PROJECT	:	Land adjacent Sefter School House, Sefter Road, Pagham
NOTE REF.	:	Acl640/21023/TN
NOTE TITLE	:	Additional Information requested by the LLFA
AUTHOR	:	Tafari Lewis
APPROVED	:	Tafari Lewis
DATE	:	11 th March 2022

This file note has been produced to provide additional information to Arun District Council (ADC) as lead local flood authority (LLFA) on drainage and flood risk for the proposed development of land adjacent Sefter School House, Sefter Road in Pagham.

A Drainage Strategy and SuDS Statement (DS) was produced by Adama Consulting Limited (ACL) in October 2021 (report ref; Acl598/21023/DS Issue 5) which was submitted supplementary to a discharge of conditions application to ADC under reference P/15/22/DOC.

Catchment Areas

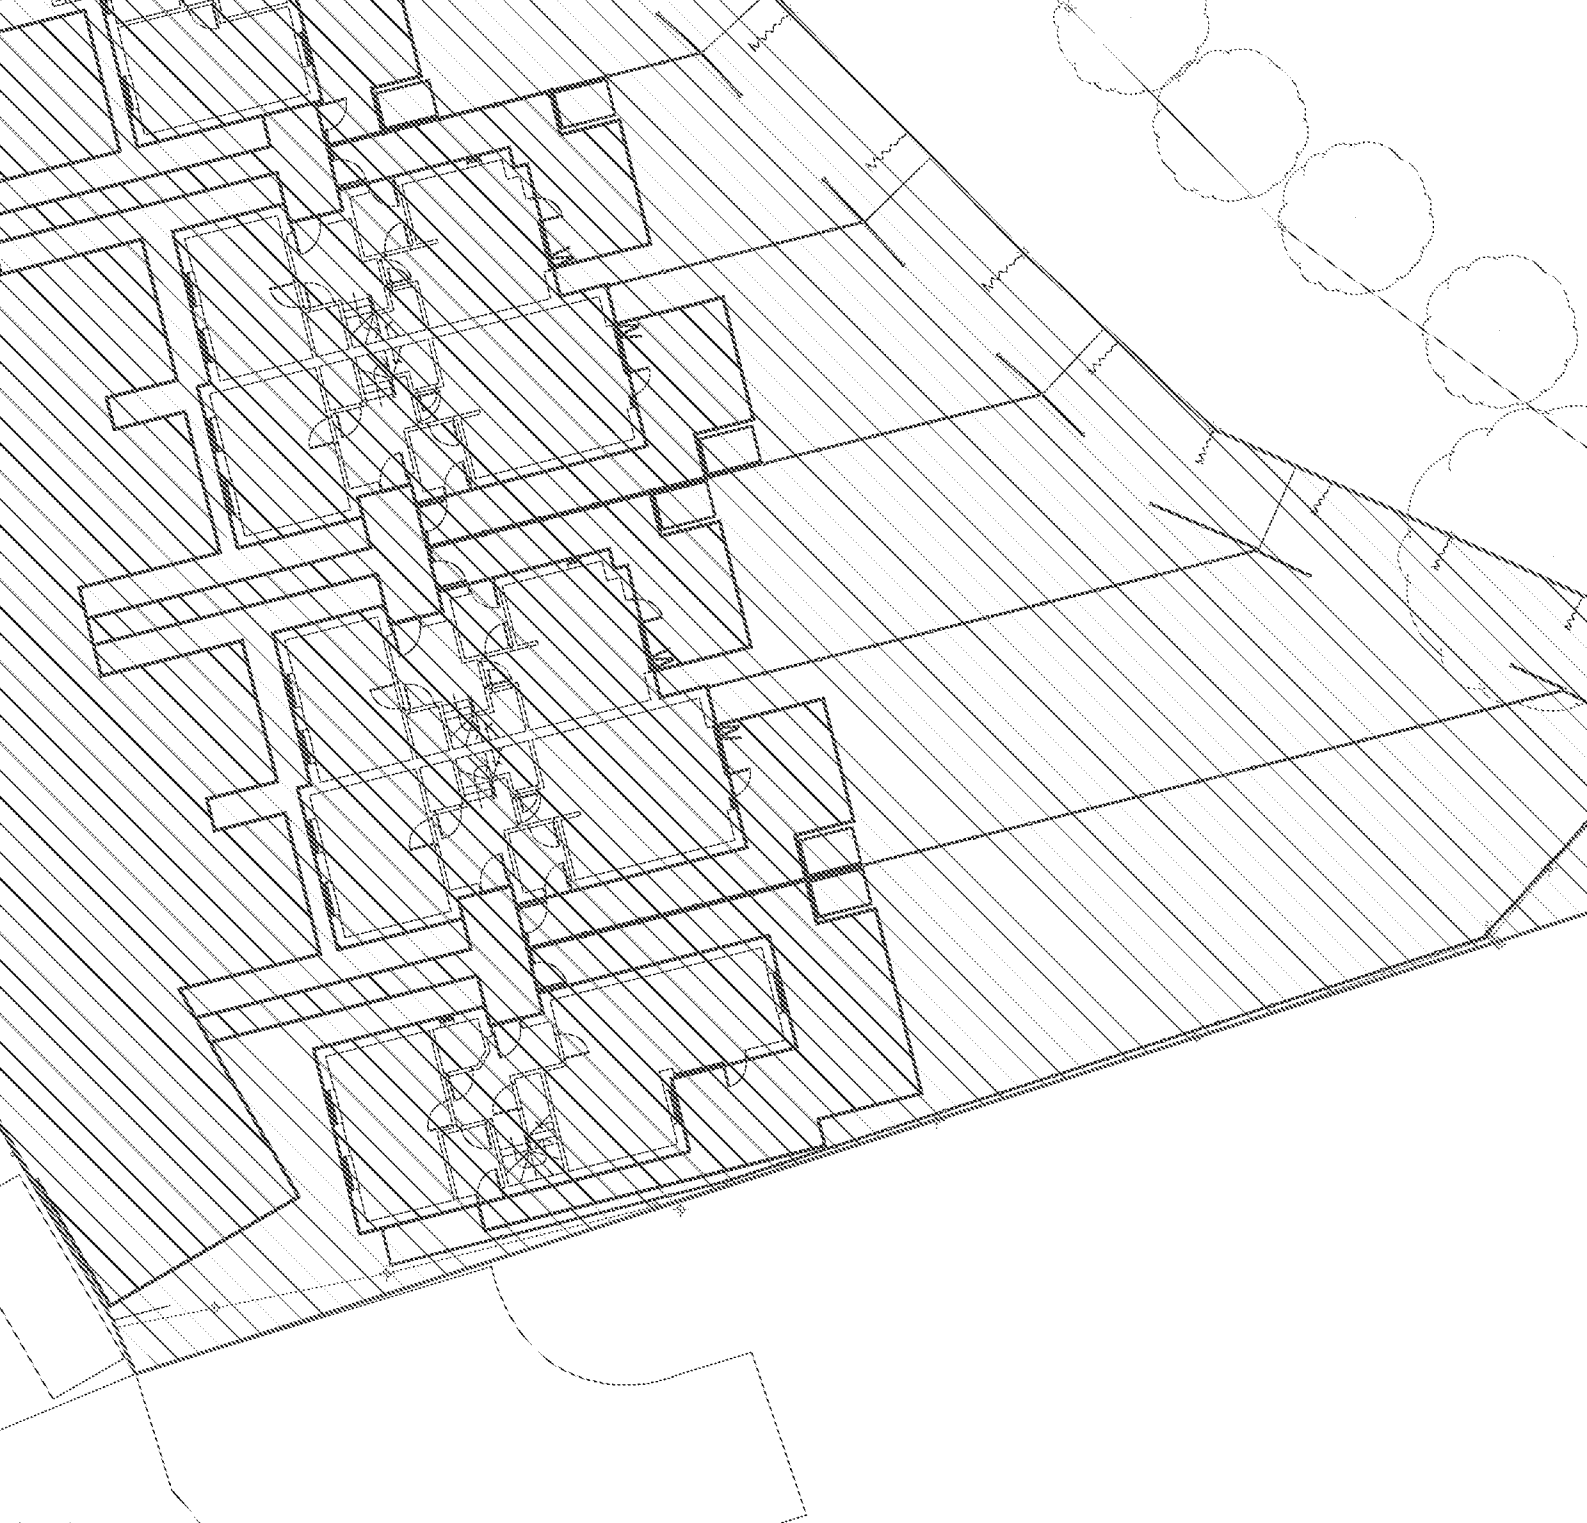
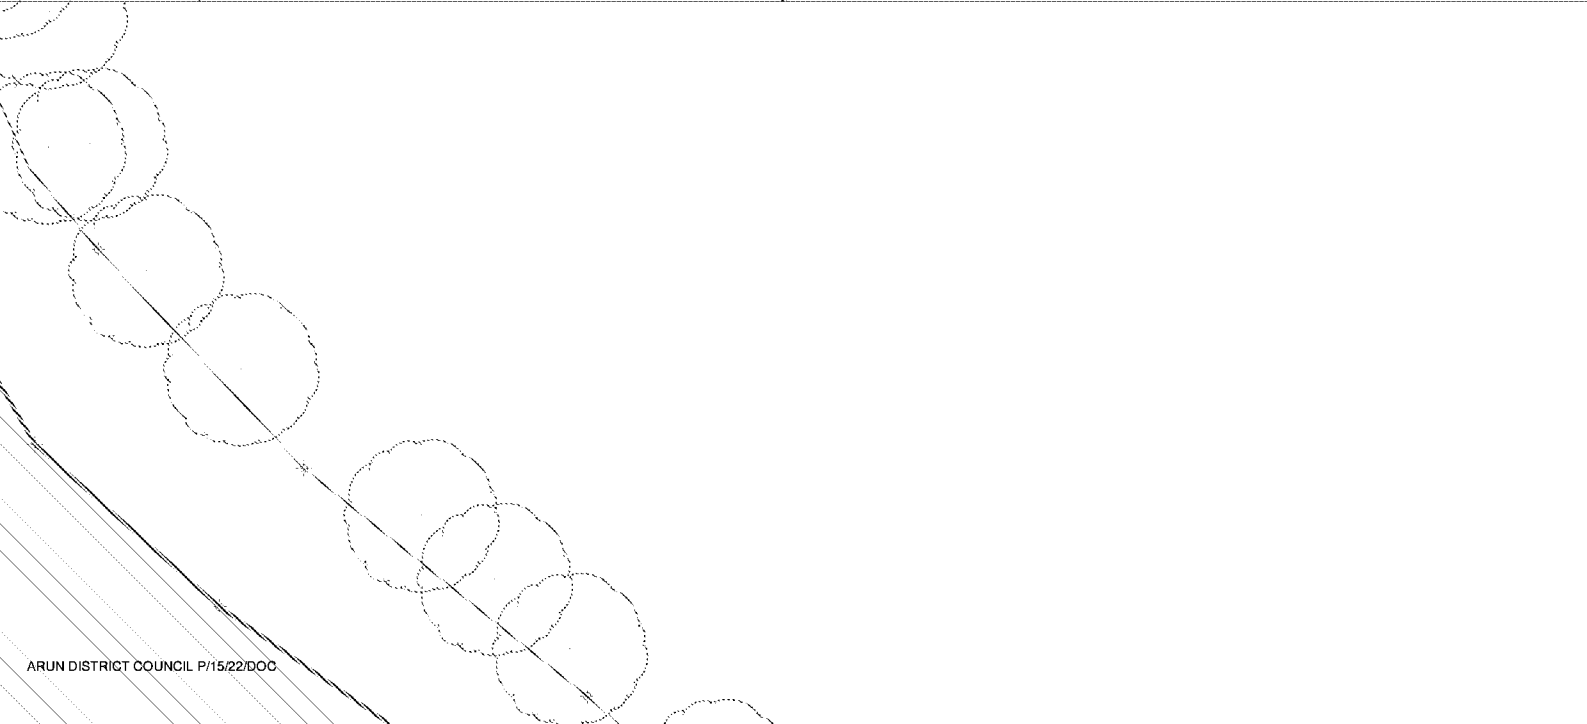
"The catchment area diagram in Appendix F has been cut and does not show the full extents of this plan. Please provide the full plan."

The full plan has been provided within **Appendix C**.
